Boston Alternative Energy Facility

Response to Environment Agency's queries on
Estuarine Processes (Tracked)

Planning Inspectorate
Reference: EN010095

Document Reference: 9.44(1)

**Figure 1.1. Ship Wash Wave Height Development over time as a Vessel Passes a Point (Gourlay, 2011)**

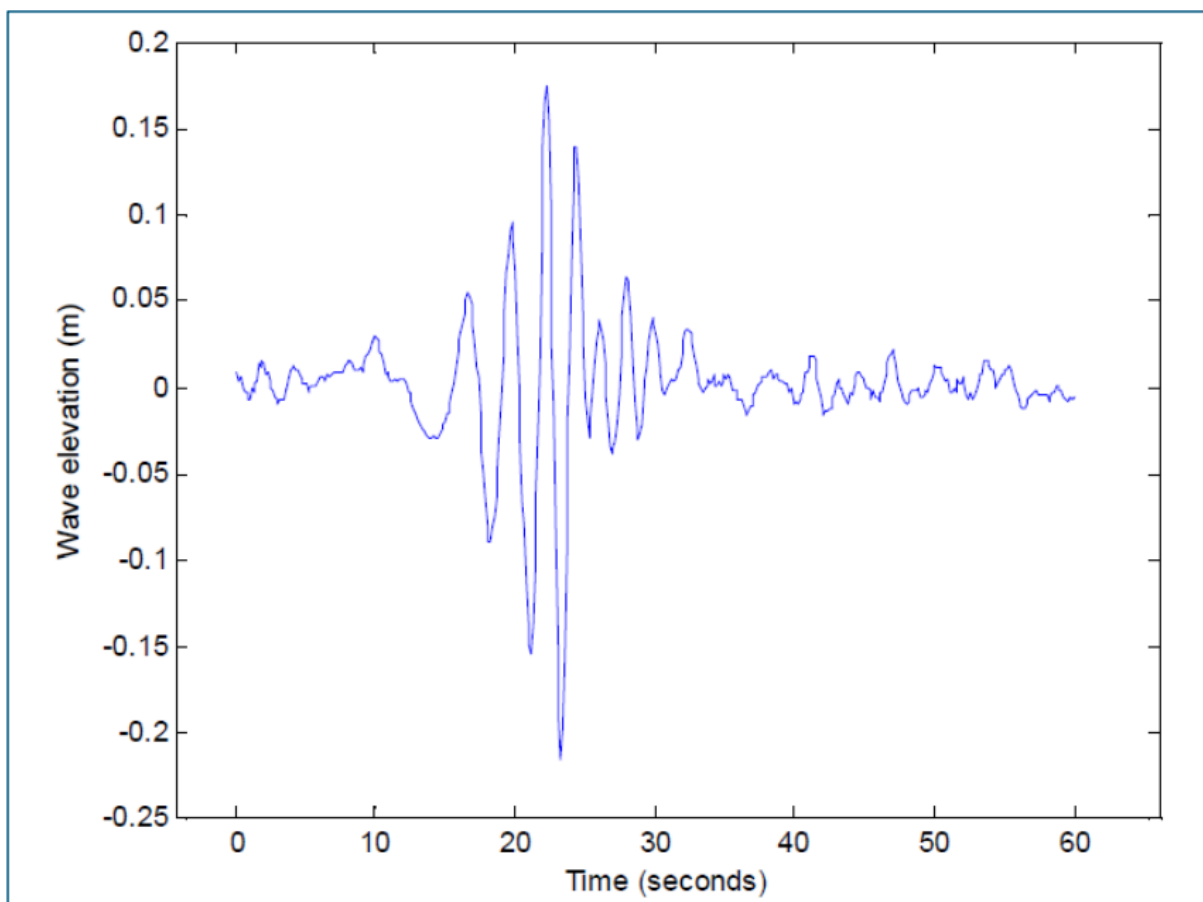
4.6. *The assessments of ship wash in Chapter 16 - Estuarine Processes of the Environmental Statement (document reference 6.2.16, APP-054) do not appear to take into account the variations in ship wash from the speed and size of the different ships expected due to the development. We note that this assessment has been done in Chapter 17 – Marine and Coastal Ecology of the Environmental Statement (document reference 6.2.17, APP-055). Ship wash will vary depending on the size and speed of the vessel. Smaller craft, travelling at greater speeds, will produce a larger and more energetic bow wave and stern/propeller wash, although for a shorter duration.*

4.7. *Ship wash may also be more severe when vessels designed for higher speeds are restricted to lower speeds, such as pilot boats restricted to 4 knots as proposed for vessels passing ships moored at the proposed wharf. We also note that the REP1-027 (Deadline 1 Submission - 9.14: Addendum to Environmental Statement Chapter 17 and Appendix 17.1 - Marine Mammals) identifies that ships will be limited to 6 knots rather than 4, and we question what impact if any this will have on the effect of ship wash.*

4.8. *We therefore ask that the detailed assessment of ship wash requested above takes into account the variation of ship types and speeds expected in the location of the proposed wharf.*

- 1.3.7 It is likely that ship wash may vary as the size and speed of the vessel vary. With respect to the sizes of the vessels using The Haven, they will be of a very similar size than the commercial vessels already using The Haven, and so from the perspective of size alone, the ship wash generated by them should be no greater than exists already. With respect to the speed of the vessels using The Haven, the maximum speed that will be allowed is signage is present stating 'six knots' but this is not a speed limit and this is not enforced the Port of Boston as the

Statutory Harbour Authority who instead rely on the Convention on the International Regulations for Preventing Collisions at Sea, 1972 (COLREGS) 'safe speed'. In the case of large shipping, safe speed is set by the onboard pilot and is based on the prevailing circumstances, conditions and proximity of other vessels. The actual speed will vary depending on the type and size of the vessel ~~but will not exceed six knots~~. It is accepted that smaller vessels travelling at higher speeds ~~(although no higher than six knots)~~ would potentially create ship wash waves that are relatively high, but they would exist over a shorter period of time, than for a larger vessel travelling more slowly. Typically, waves created by ship wash only last for less than 10 seconds with peaks heights of around 0.4m (**Figure 1.1** **Figure 1.1**) (Gourlay, 2011). Hence, if higher waves are generated over a shorter period of time (by faster moving small vessels), they would produce similar levels of energy at the shoreline compared to relatively low waves generated over a longer period of time. The possible height and time scale combinations that could be caused by different vessel sizes and speeds, would effectively balance each other out in terms of the energy impinging on the shoreline.

- 1.4.4 A typical ship wash wave is about 0.4m high, lasting for about 10 seconds and reducing to less than 0.1m after that (**Figure 1.1** ~~Figure 1.1~~) (Gourlay, 2011). In this case, a wave 0.4m high would impact on the opposite shore a short time after the direct ship wash wave impacts that shore. So, for every day of a year the number of ship wash events on the bank opposite the wharf will be doubled compared to the current baseline. If a situation arises where the berths are empty, ship wash would be restricted to the direct wave from a vessel travelling past the wharf, and there will be no reflected wave off the sloping revetment and wharf piles for the reasons stated in Section 1.2.1.
